POWELL AMENITY CENTER & POOL

**HARNETT COUNTY PLAN REVIEW APPLICATION
SWIMMING POOLS**

Powell Amenity Center
212 Perseus Street Angier, NC

To Whom It Concerns
Attn: Cindy Pierce
RE: Plan Review

ENLARGED PUMP ROOM PLAN

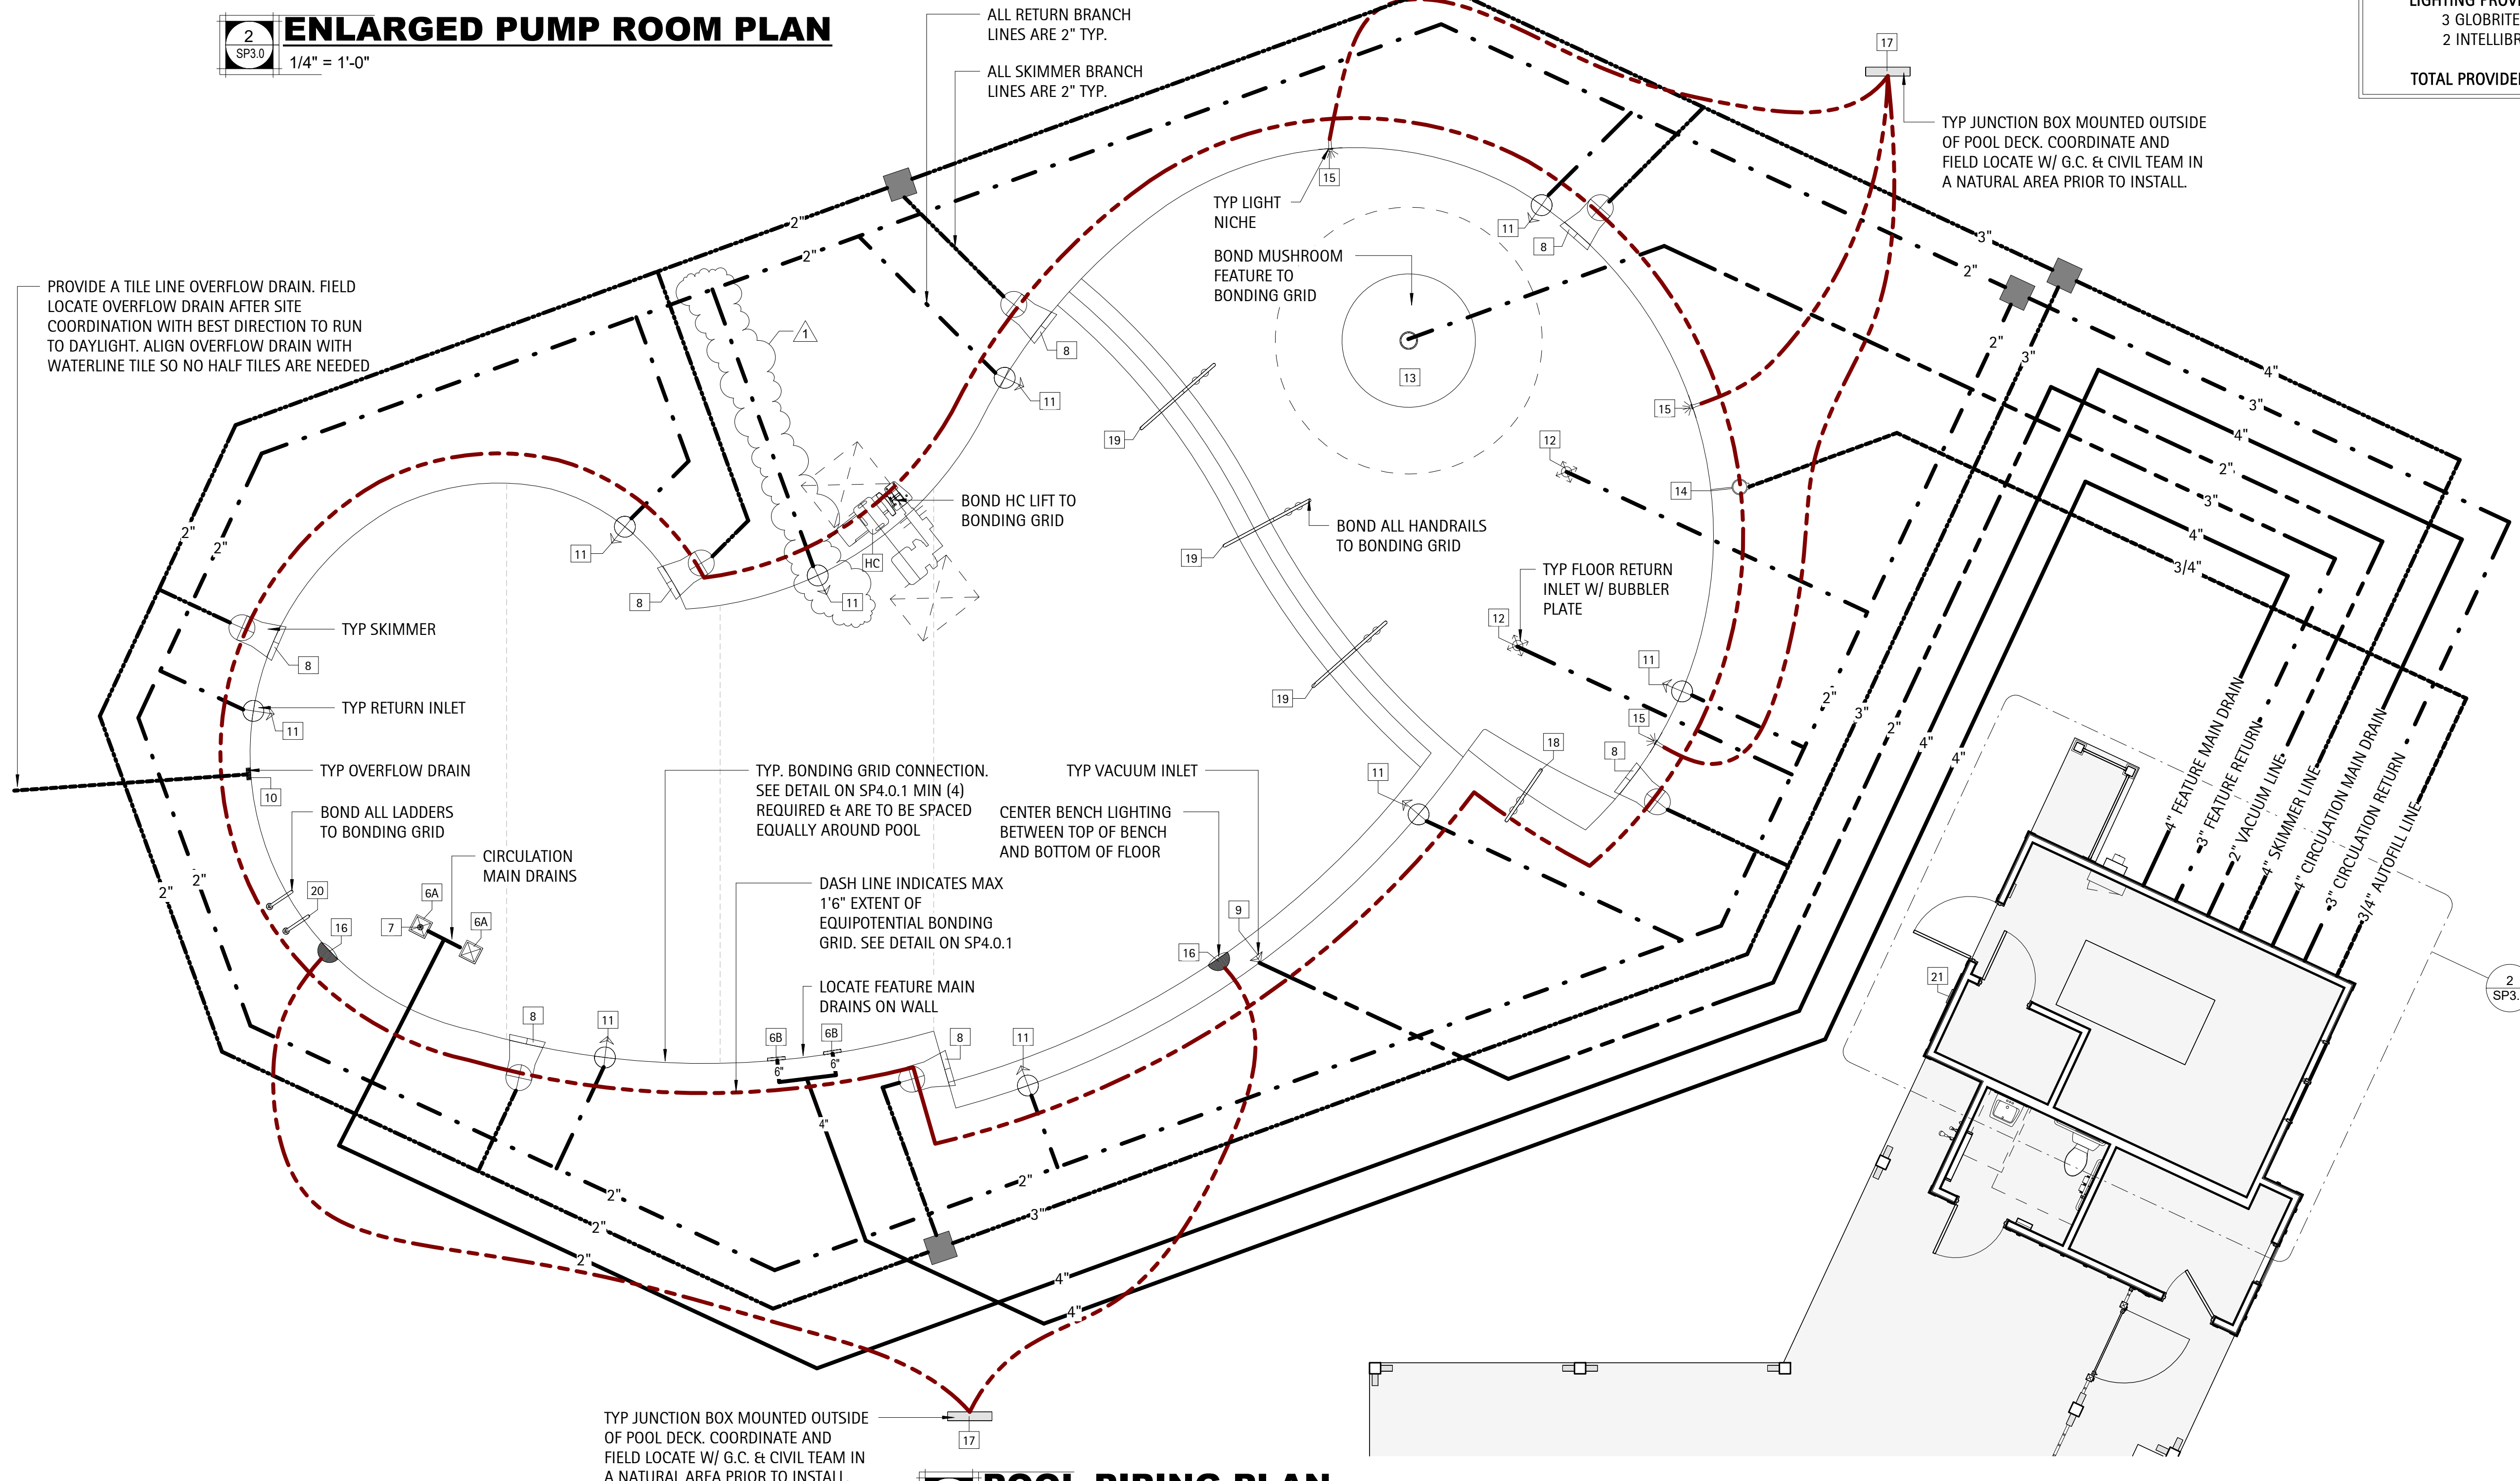
3. Circulation Main Drain Line on SP3.0.1.
 - a. There is a typo on the main drain line that states 2" when it should read 4".
4. Item # 16 – Pool Light (601108) 400W Equivalency Intellibrite White LED Light

6 Detail - Main Drain  
1" = 1'-0"

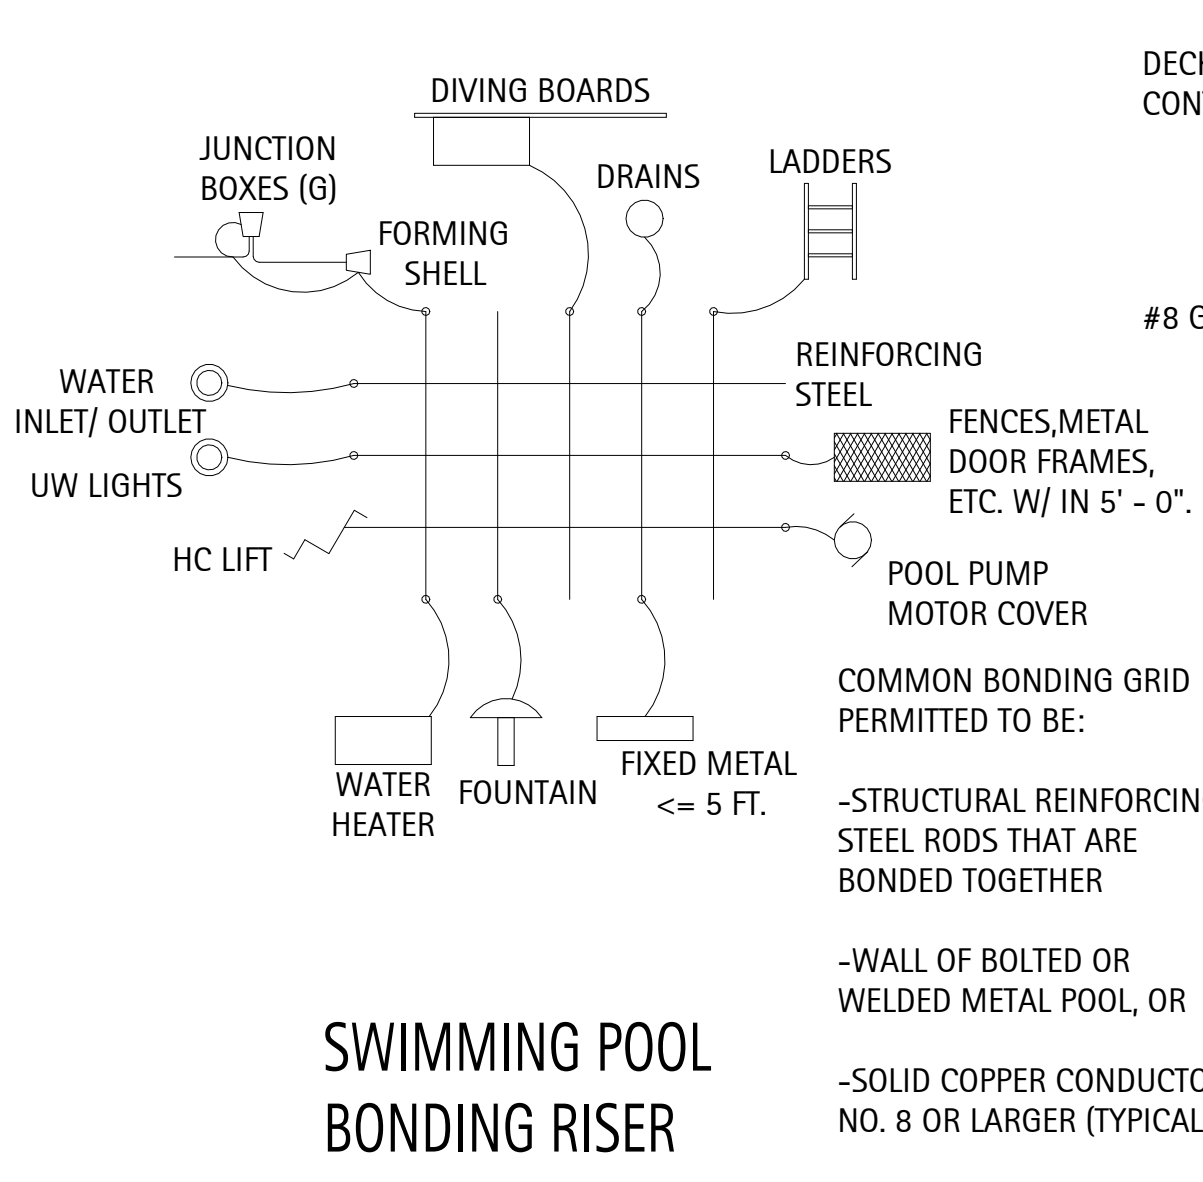
1. Circulation Main Drain Cover & Sump (9MF-101 w/ FBS-50-809-3)
 - a. Updated plans will reflect WAV12WR101 w/ FBS-50-812-4. Schedule, Main Pool Data Sheet & Pool Specifications will be updated to reflect this change as well.

2. Feature Main Drain Cover & Sump (1216101 w/ FBS-50-812-6)
 - a. Updated plans will reflect 1216101 w/ FBS-50-812-18-6. Schedule, Main Pool Data Sheet & Pool Specifications will be updated to reflect this change as well.
